East Anglia One North (EA1N) and East Anglia Two (EA2) Offshore Wind Farms

Planning Inspectorate Reference: EA1N – EN010077, EA2 – EN010078

Deadline 8 – 25 March 2021

Comments of Suffolk County Council as Lead Local Flood Authority

Figure 1-3 - Culvert and Flood Storage Area Location

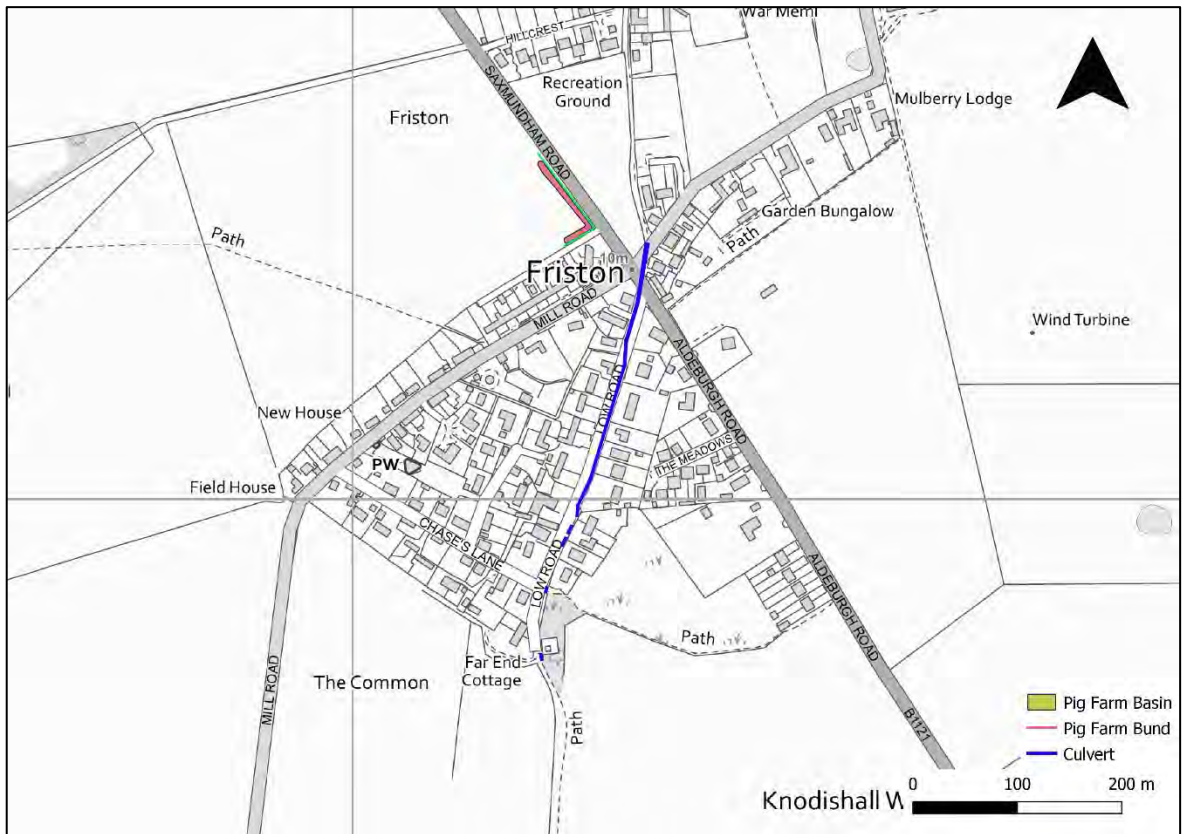
The proposed relocated flood storage basin location is not acceptable to SCC as it does not serve the same extent of the catchment as the existing feature.

Infiltration Basin Structure

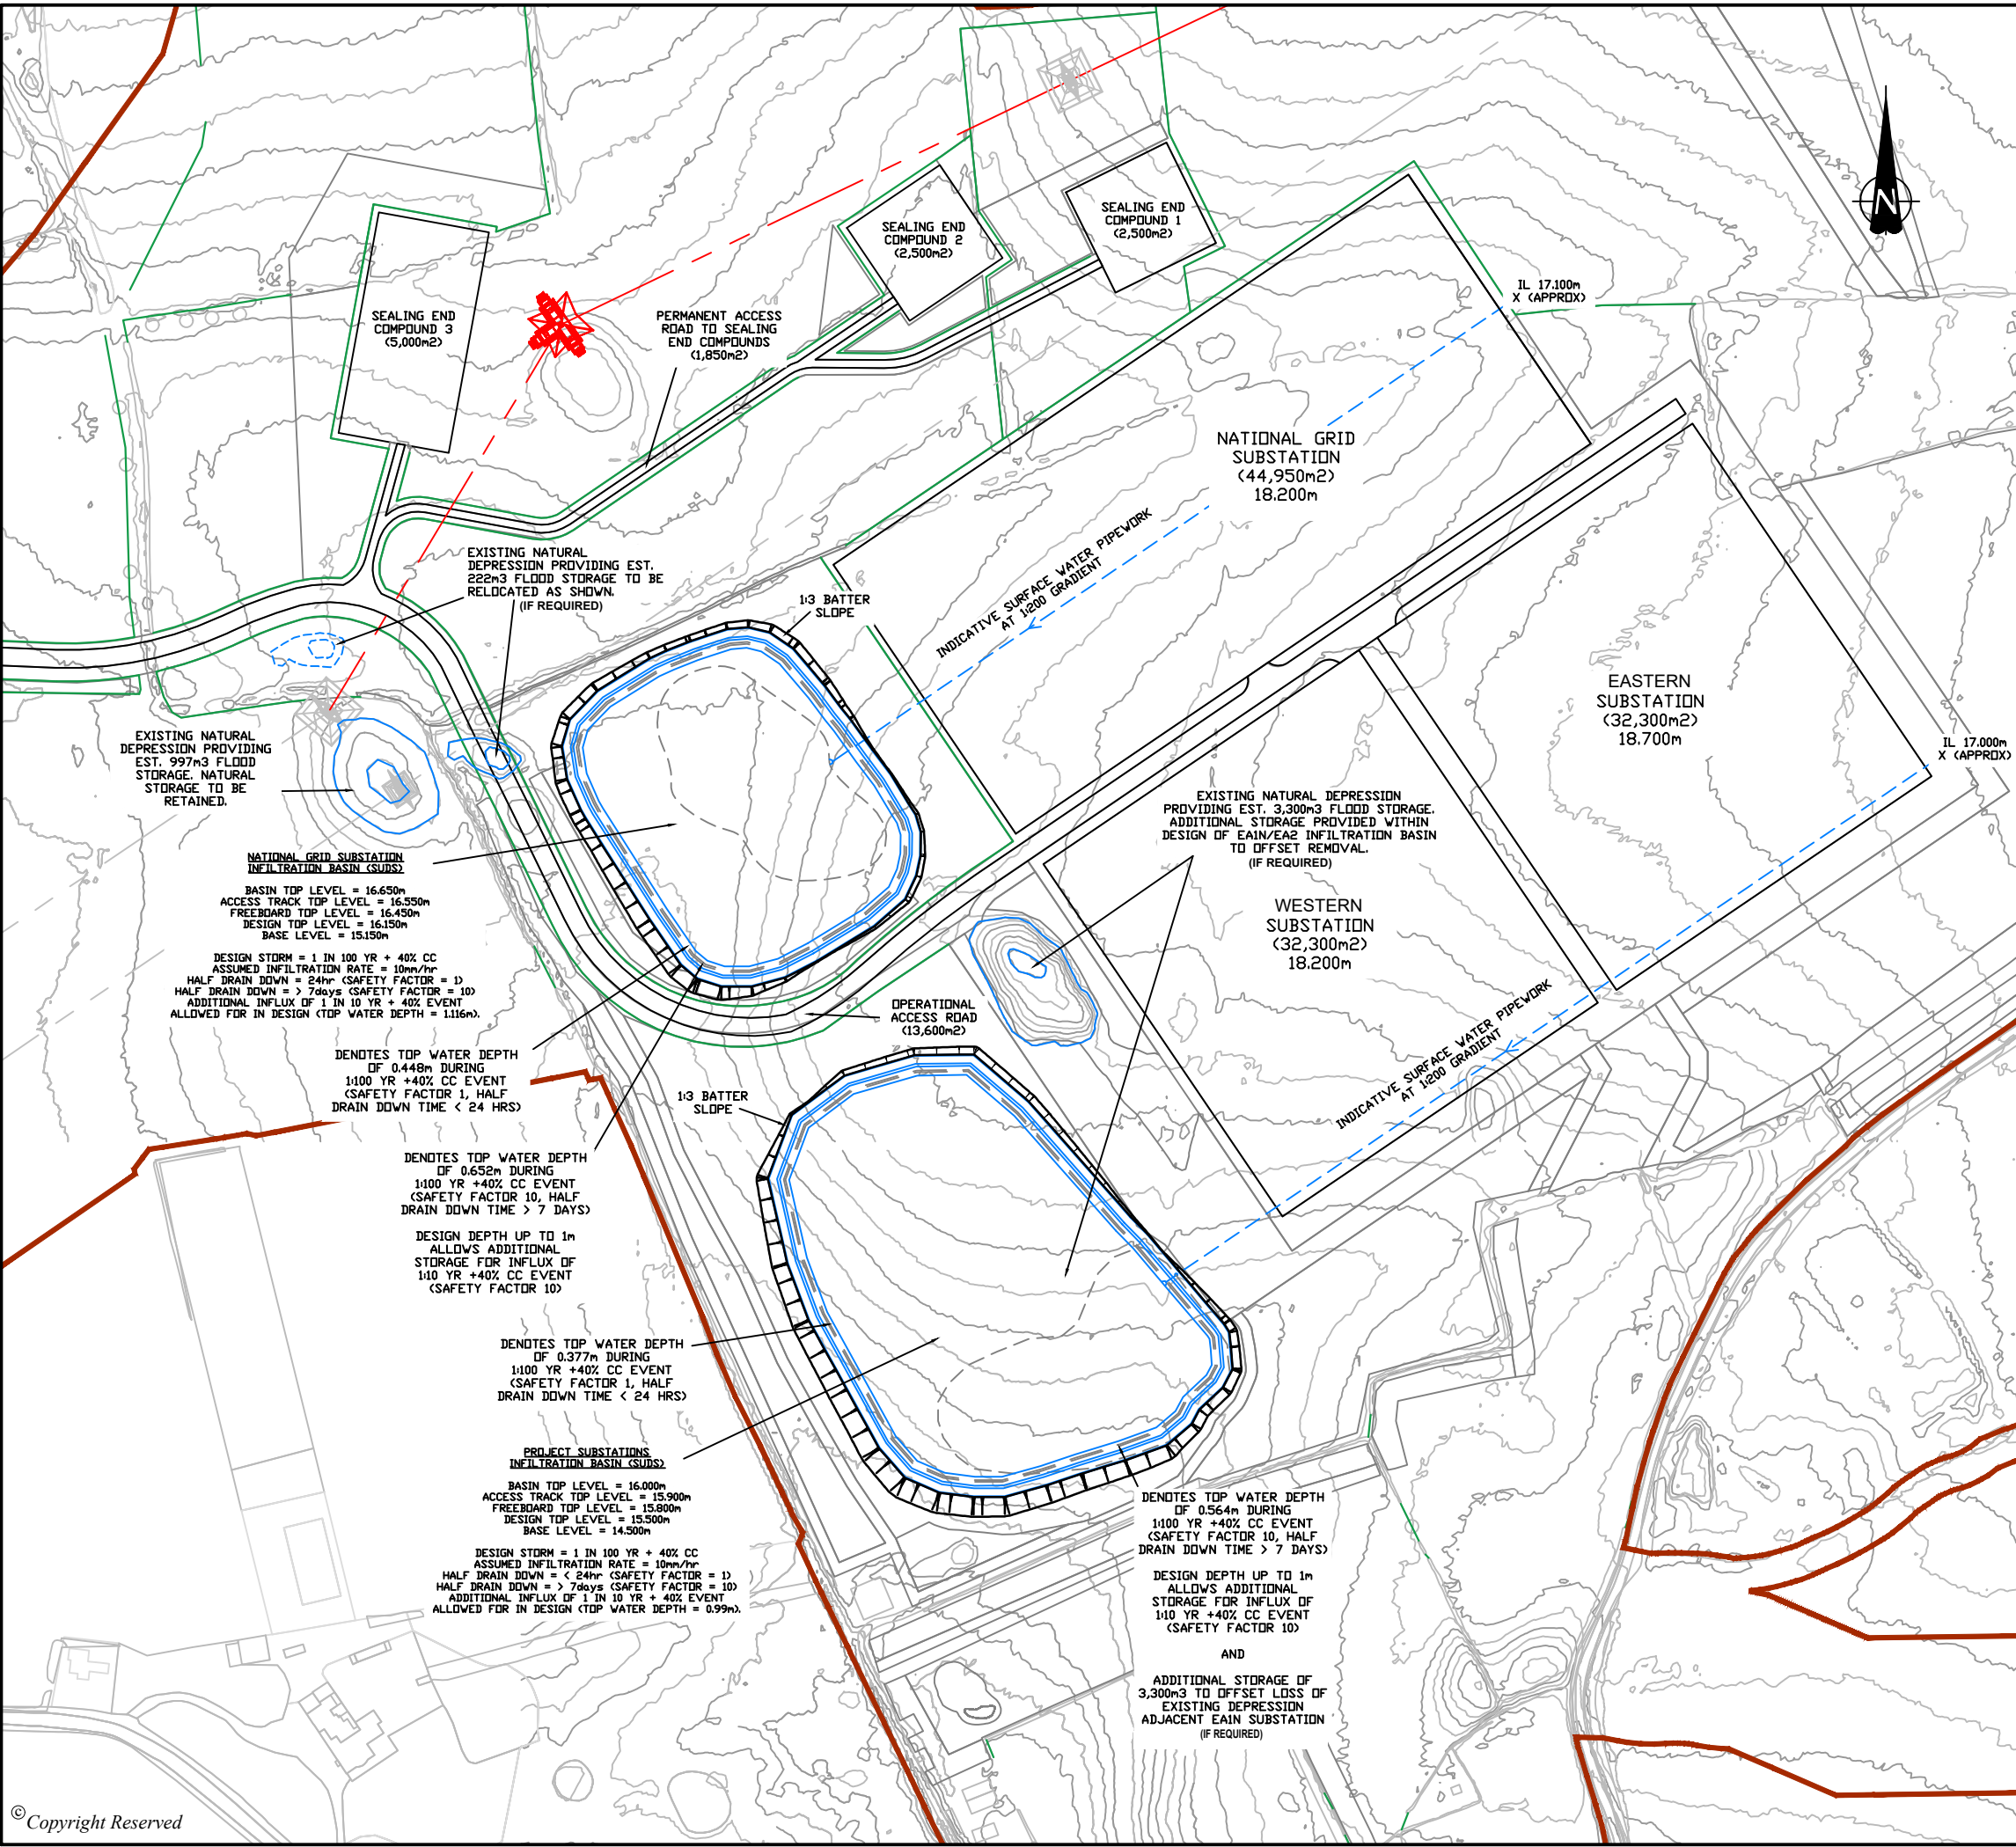
The 10mm/hr infiltration parameter is used for the sizing of SuDS components only. To state that infiltration is not feasible/viable based on this assumed rate is misleading. Whilst the Applicants point regarding half drain time is noted, this can be addressed in one of two ways. Increase the plan area of the basin, or, provide additional storage for a 1 in 10 year rainfall event after 24 hours. The Applicant has demonstrated that the latter option is deliverable with an infiltration only approach in the Deadline 6 OODMP. On this basis, SCC consider this to be a design check pass, which by definition, demonstrates that an infiltration only approach is technically viable.
